Development Facilitation Team (DFT) – Review Comments

Project No: PR-2025-020067 Date: 6/11/2025 Agenda Item: #7 Zone Atlas Page: H-16

Request: Eliminate lot lines to create 2 new tracts from 4 existing tracts. Vacate and relocate existing 30' private access and drainage easement. Dedicate 4' RW along Vassar.

Application For: MINOR PLT-2025-00021 – MINOR PRELIMINARY/FINAL PLAT

EXISTING CONDITIONS, VACATIONS & DEDICATION

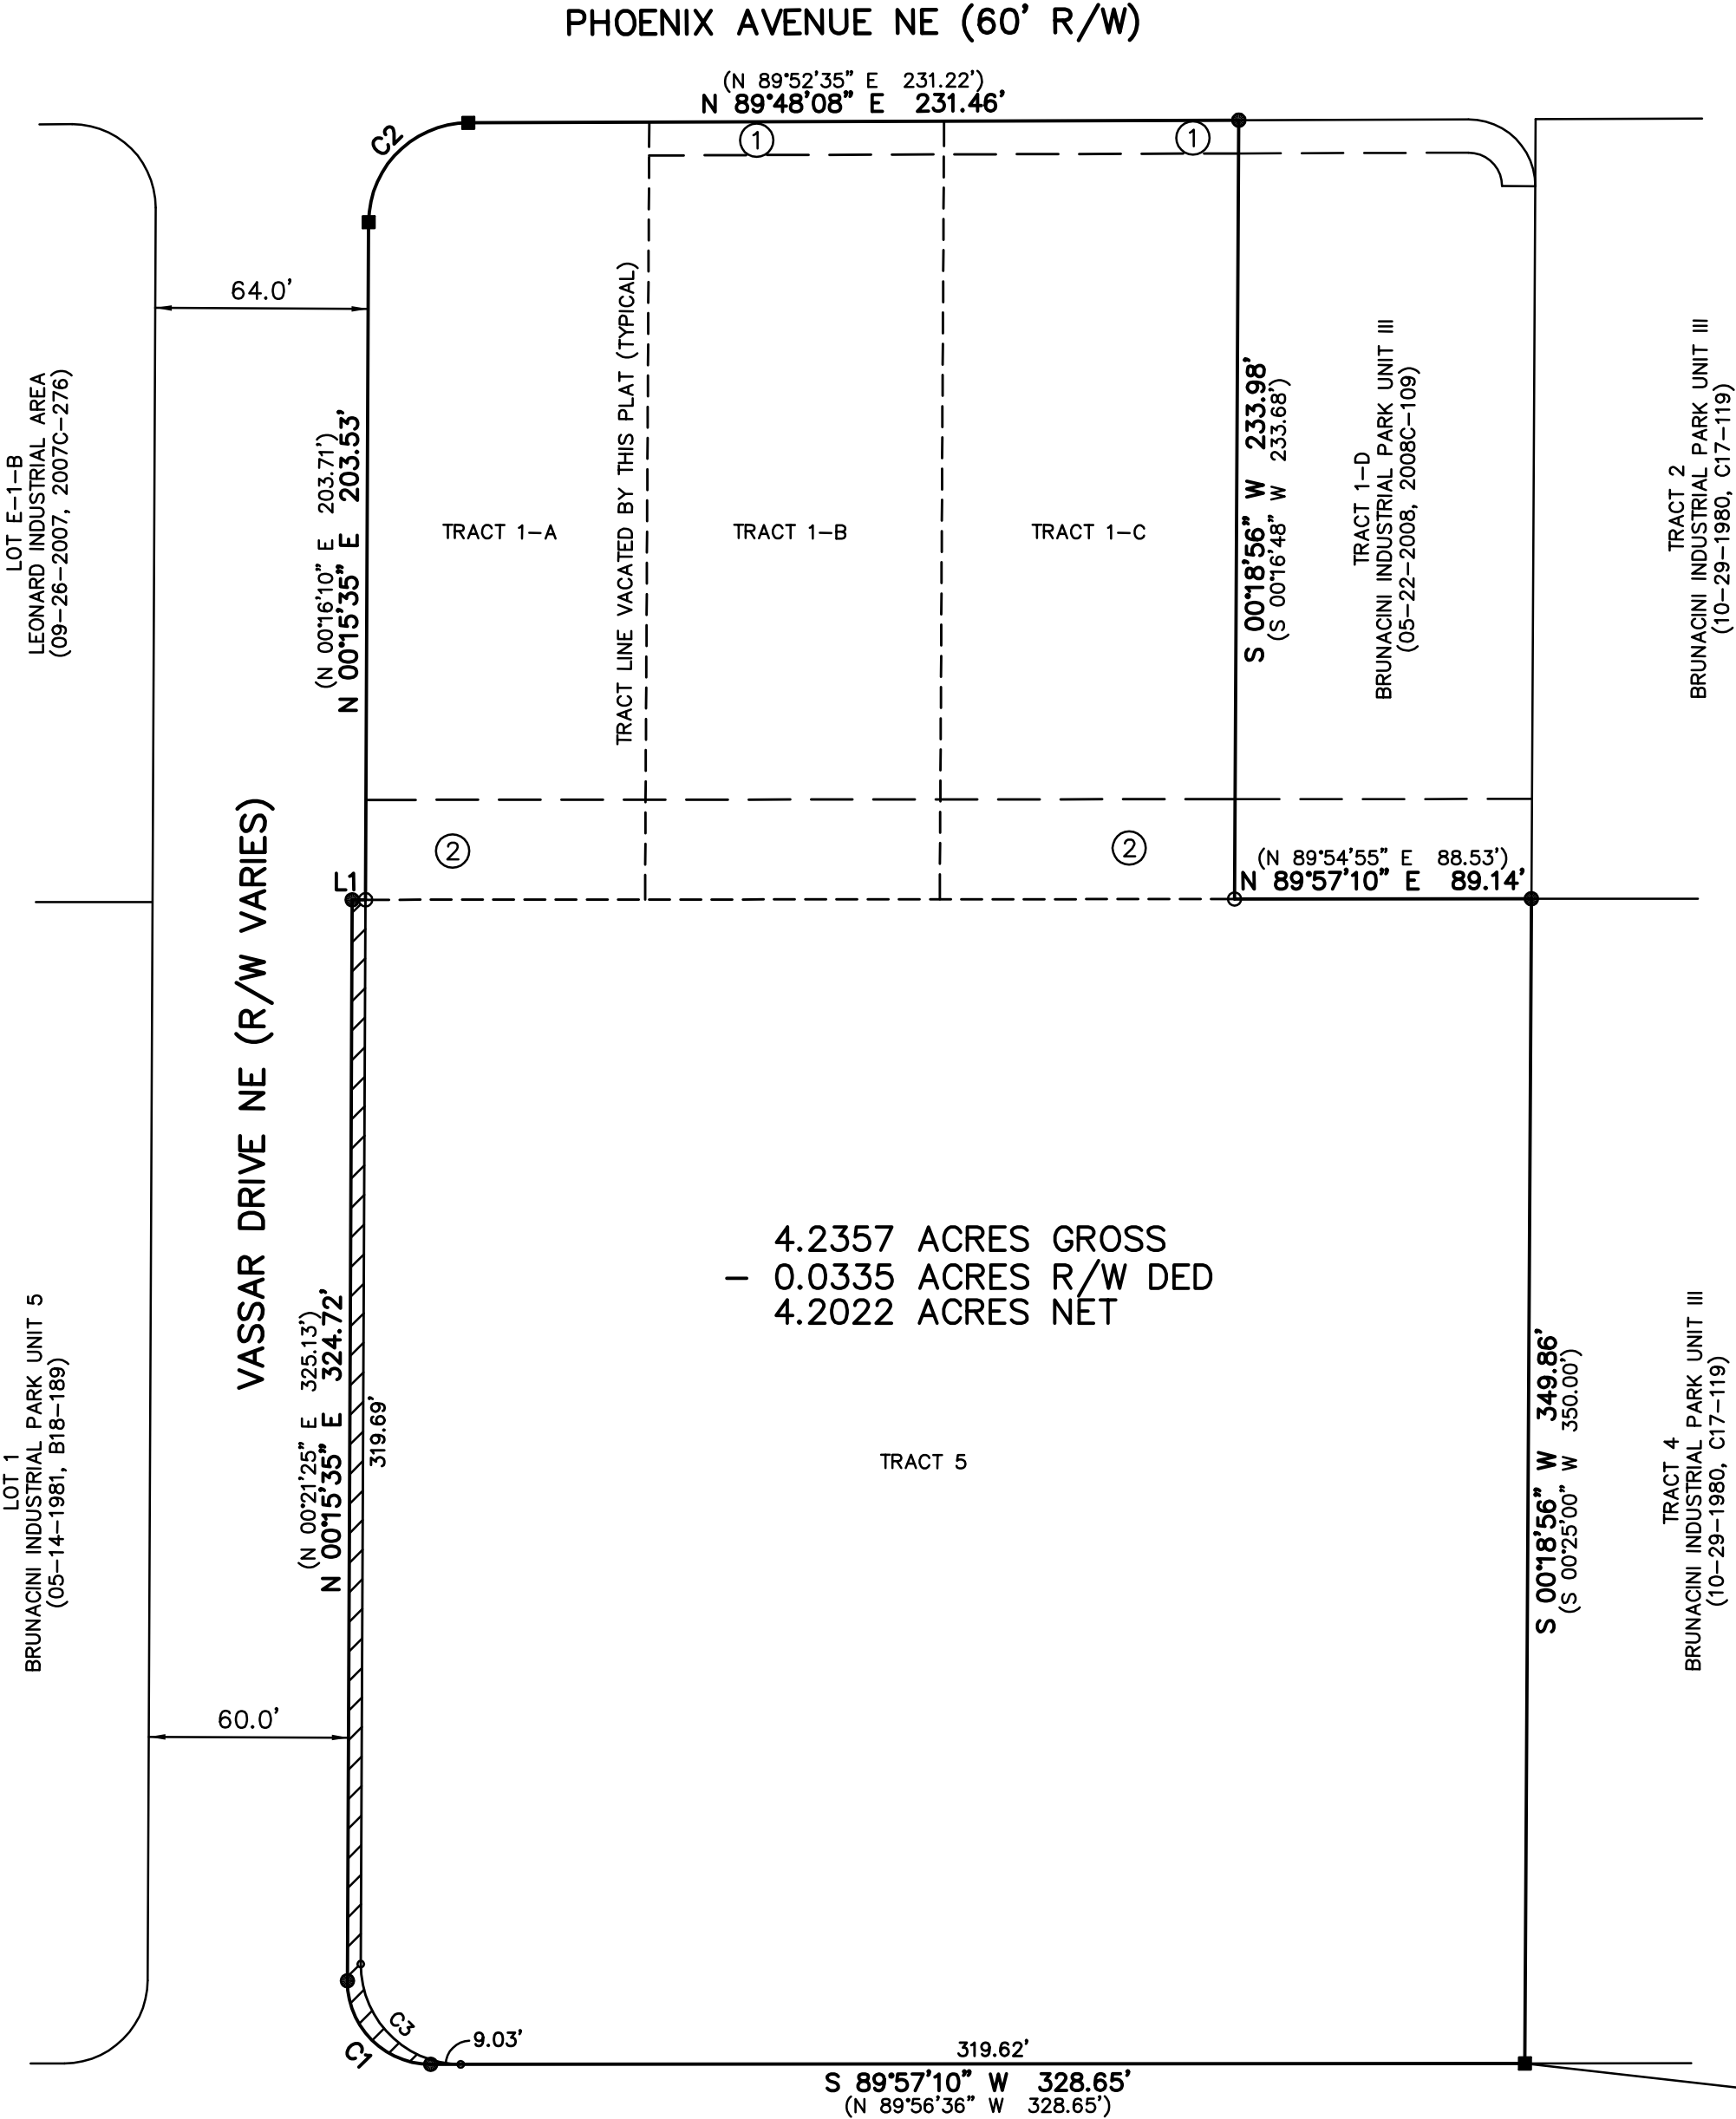
- Per Transportation, the site is not meeting DPM requirements for sidewalk width and landscape buffer. *Clarify if an IL will be a part of this platting action.
- Per Hydrology, a G&D is required for the proposed platting action.
- More detail is needed on the justification letter. It did not clearly explain existing conditions vs. propose changes for the entire site. More importantly, it did not detail the required IDO criteria for a vacation action.

- Confirm that Tract 2 & 4 to the east and Tract 5-B to the south are not a part of this platting action.
- Clarify access from Menaul to this subject property and the proposed vacated area. That drive isle also provides access to the properties to the east (existing gate).
Is that a platted access easement?
Is there a cross-access easement for the business/lots to the east?
Will that access affect your proposed vacation?

- NEW EASEMENTS
- ③- 10' PUBLIC UTILITY EASEMENT (PUE)
(GRANTED BY THIS PLAT)
 - ④- 30' PRIVATE ACCESS & DRAINAGE EASEMENT
FOR THE JOINT USE, BENEFIT AND TO BE
MAINTAINED BY TRACT 2, 3, 4 & 5-B.
(GRANTED BY THIS PLAT)

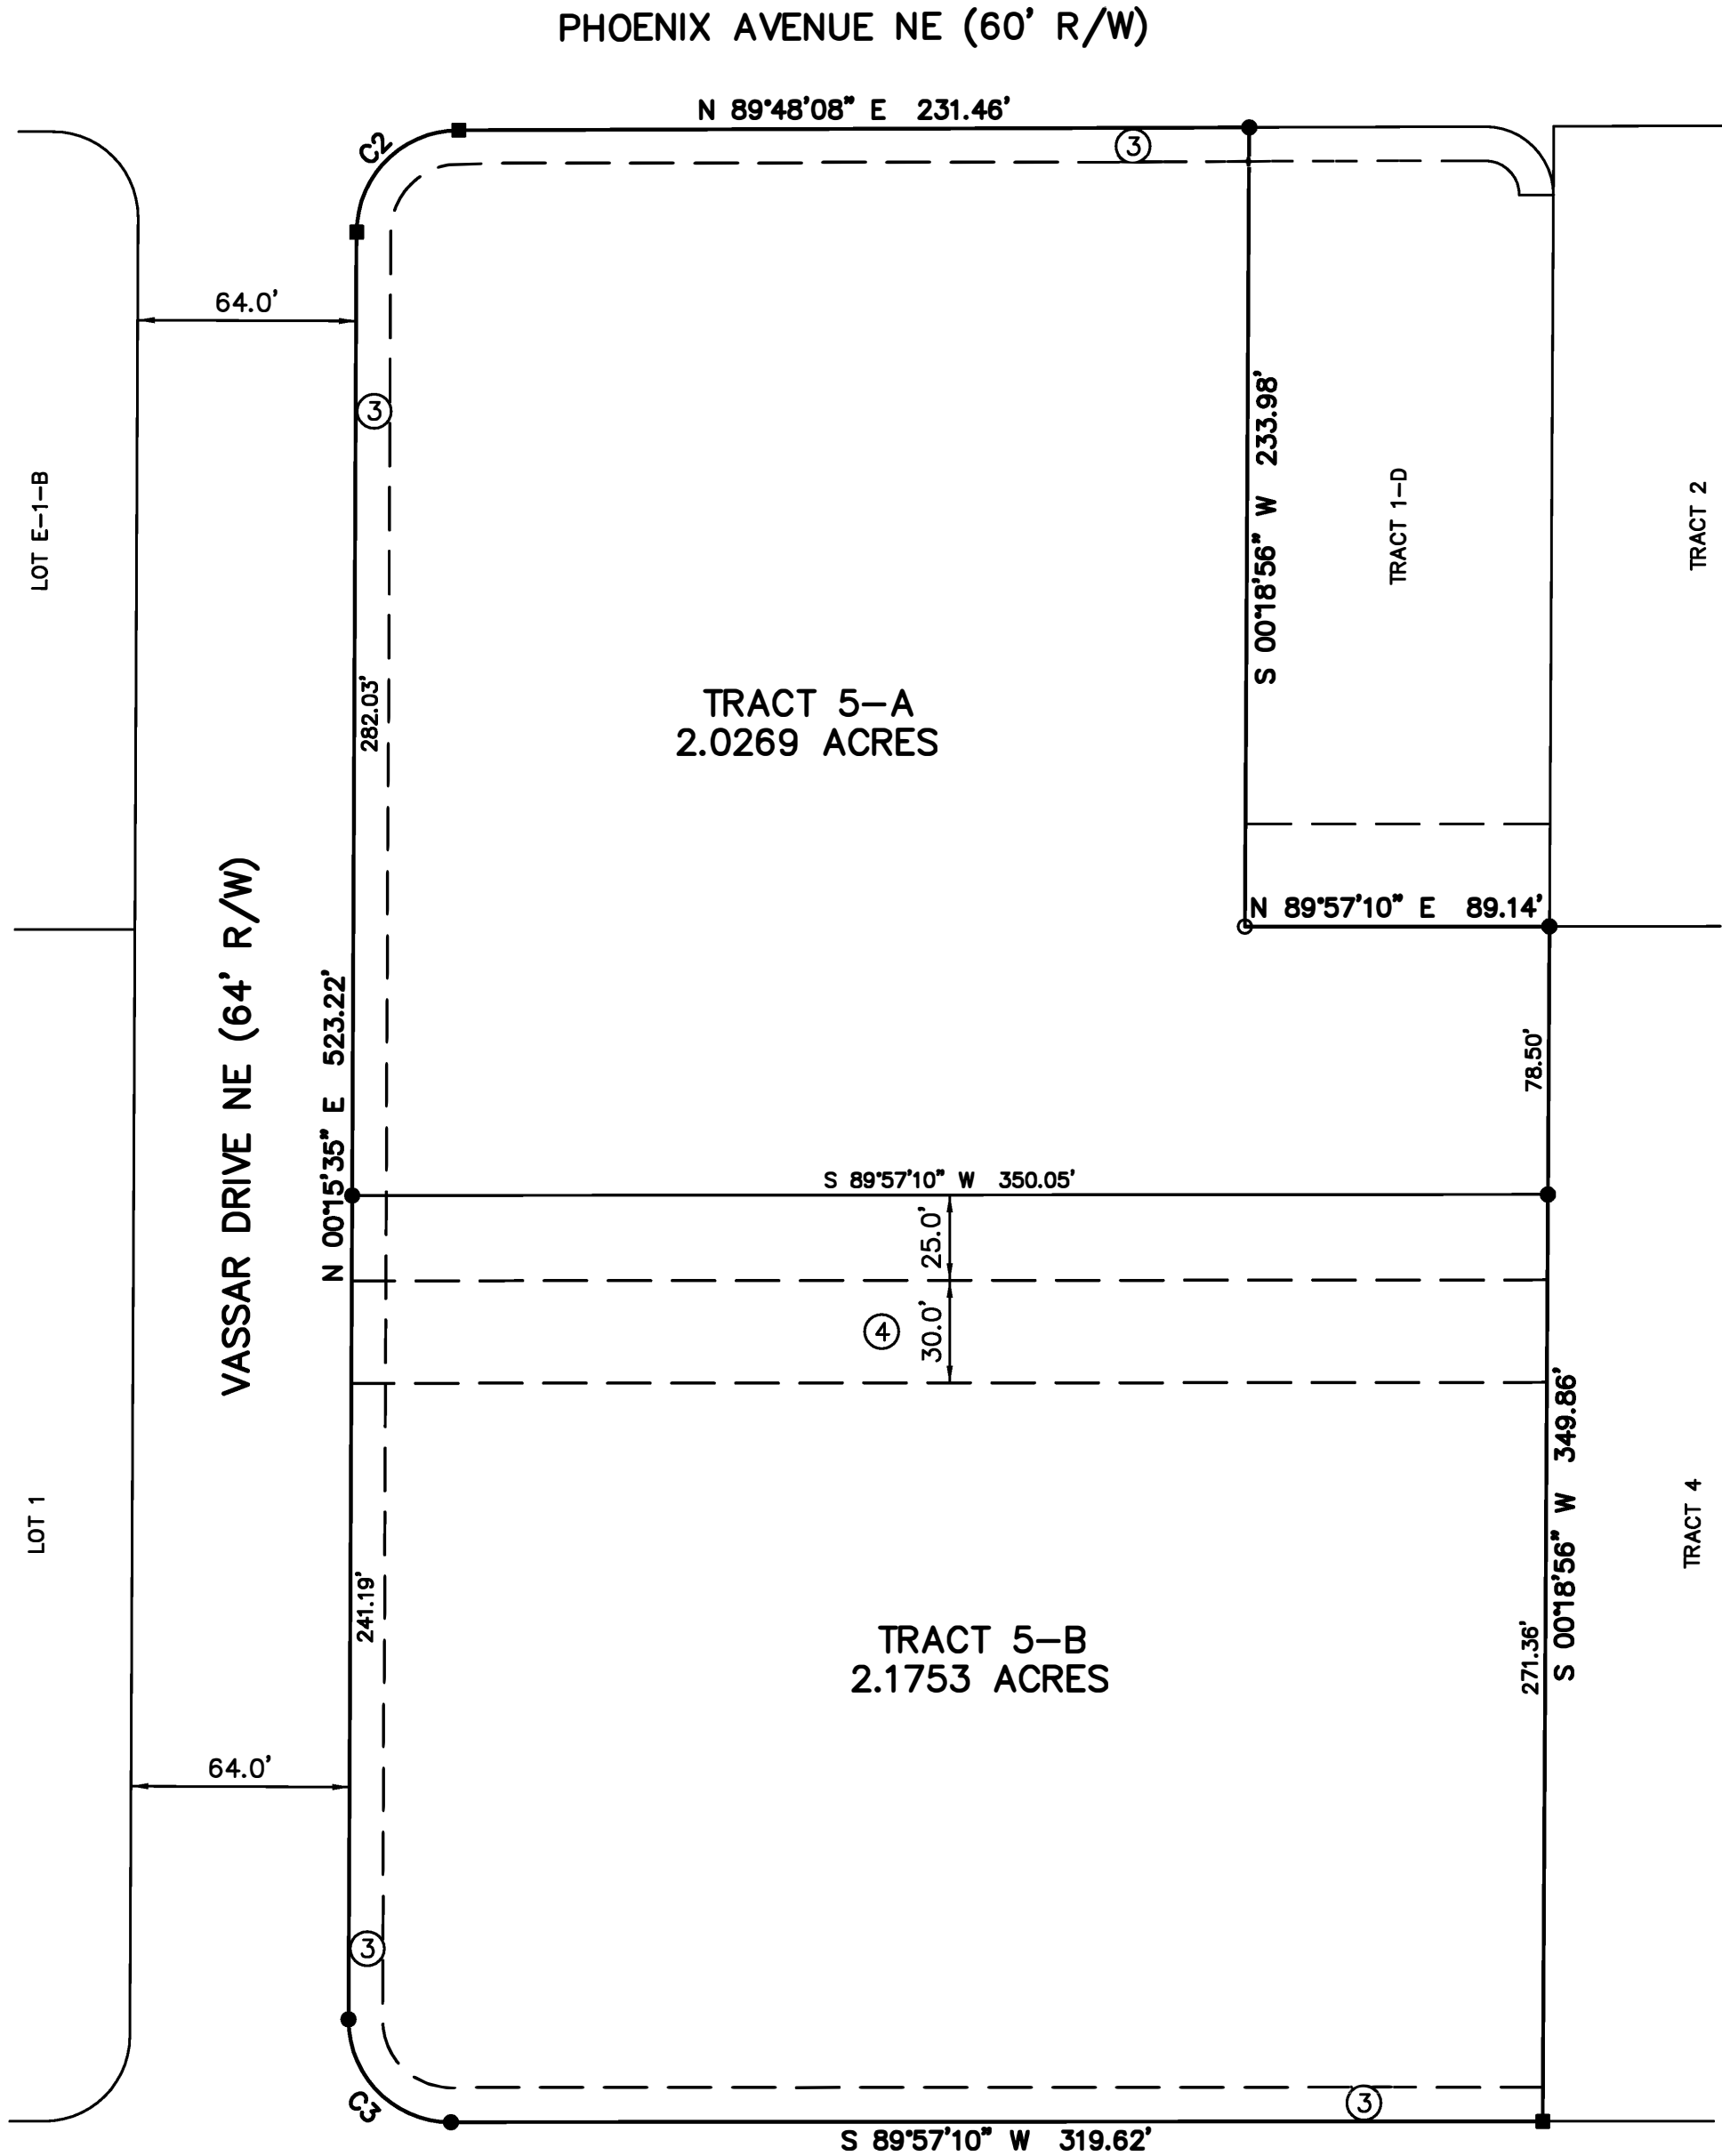
1. There are no easements being granted and the note regarding Water Authority easements can be removed.
 - a. Please add the following note on the proposed plat. (Previous comment)
 - i. “Existing public water and/or sanitary sewer infrastructure may not be constructed or sized to adequately serve potential future development. Improvement or upsizing of existing public infrastructure may be required as a condition of future development approval.”
2. For future development, please place a Request for Availability online at the following link:
http://www.abcwua.org/Availability_Statements.aspx. Requests shall include fire marshal requirements.
